PINS Ref. EN010079

Application by Norfolk Vanguard Limited for an Order Granting Development Consent for the Norfolk Vanguard Offshore Wind Farm – Deadline 7 submission.

I write following the Issue Specific Hearing 6: Environmental Matters on 24 April 2019. The Examining Authority requested that the District Council provides the following:

Figure 1 Location of Old Railway Gatehouse

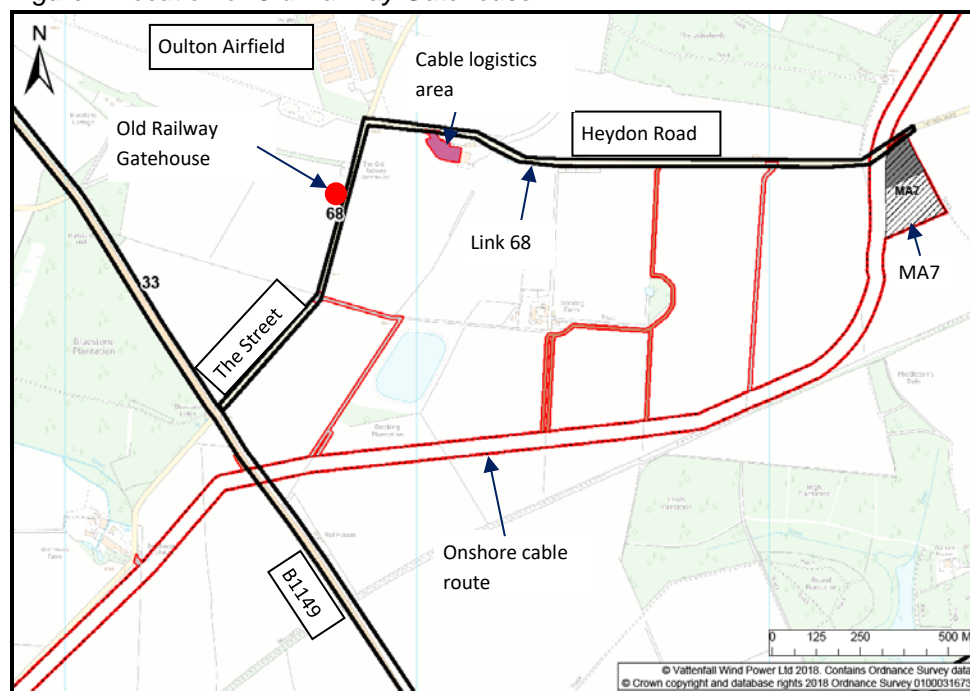
It is presumed that the applicant will have used Defra background level information.

Oulton Parish Council are correct to state that local sources of pollution should be taken into account and the turkey sheds and pig rearing units are close by and may be included in the modelling figures that are publically available. Planning permission has been granted for 6 no. biomass boilers for heating the nearby poultry sheds. This combined emission will increase pm10 and pm 2.5 locally.

In respect of ammonia I understand it can combine with substances in the air to produce pm2.5. It is felt that it would be useful if the applicant could comment on any local effects.

It is felt that the applicant should take account of Oulton Parish Council's concerns and include/make sure that background levels reflect local point sources as above.
